CITY OF ALBUQUERQUE

RE: 13704 Ellena Gallegos NE
Grading Plan
Stamp Date: 7/18/17
Hydrology File: E24D002A

LEGAL DESCRIPTION:
Lot 95 Unit 3 of the Highlands at High Desert

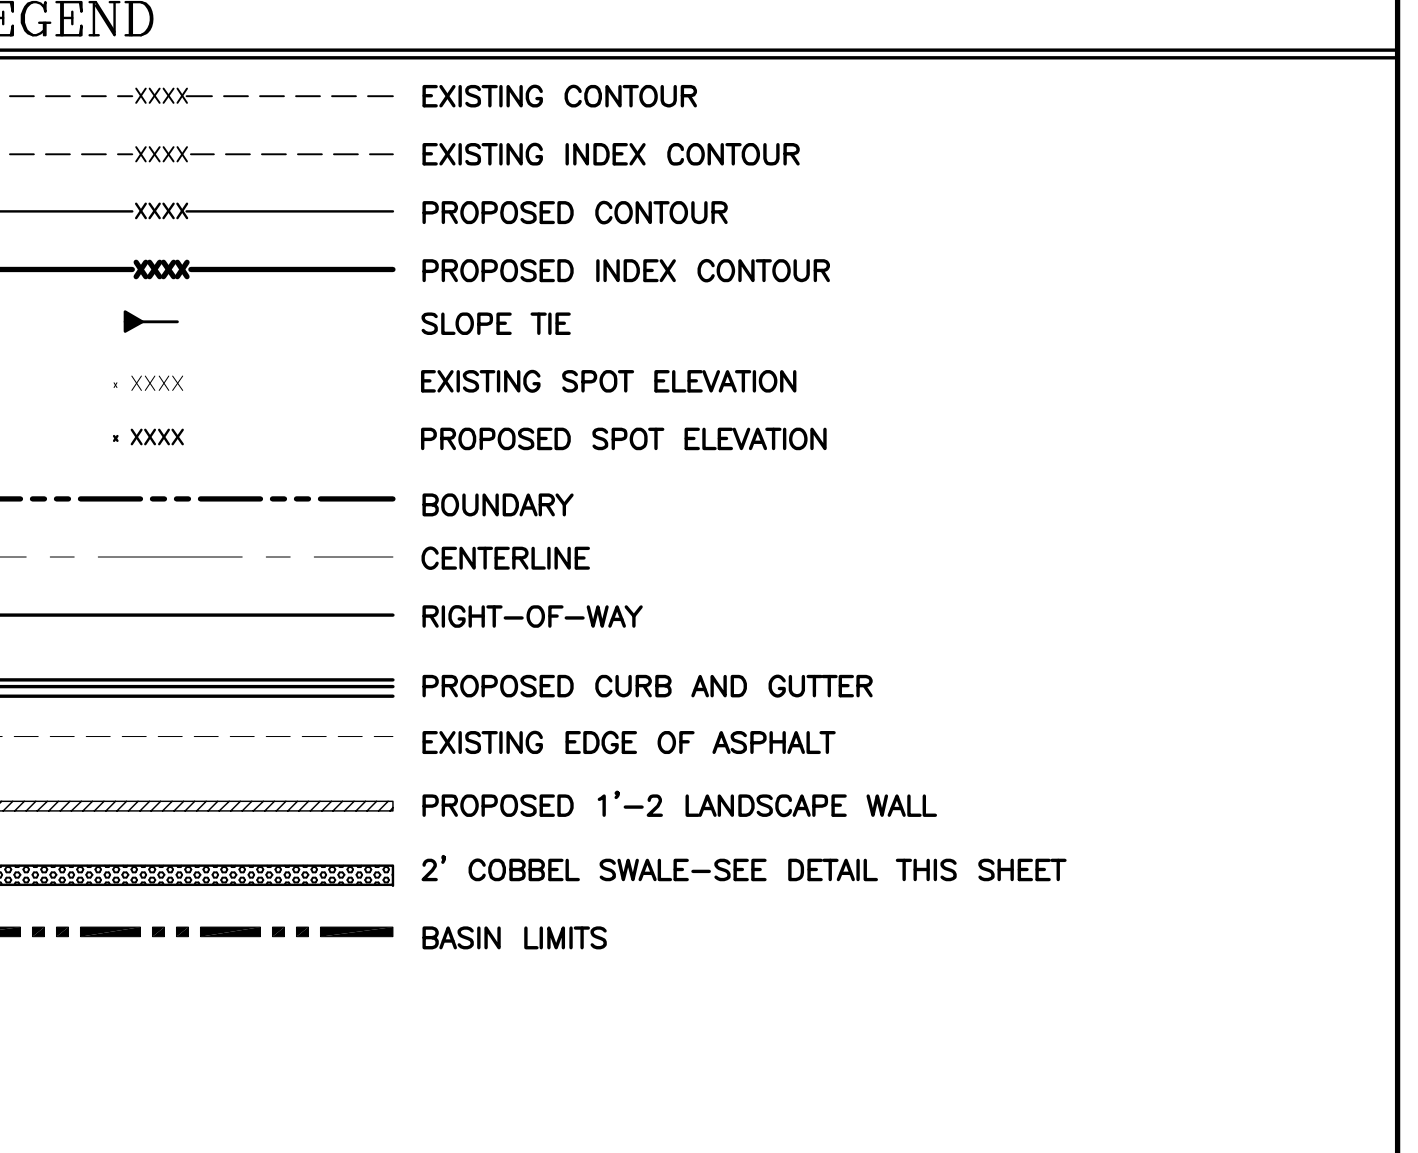
1. Please provide both the beginning and ending flowlines for all the cobble swales.
2. Please add the weir calculations for the emergency overflows.
3. There is enough room on the sheet, so please enlarge the Site Hydrology calculations and notes.
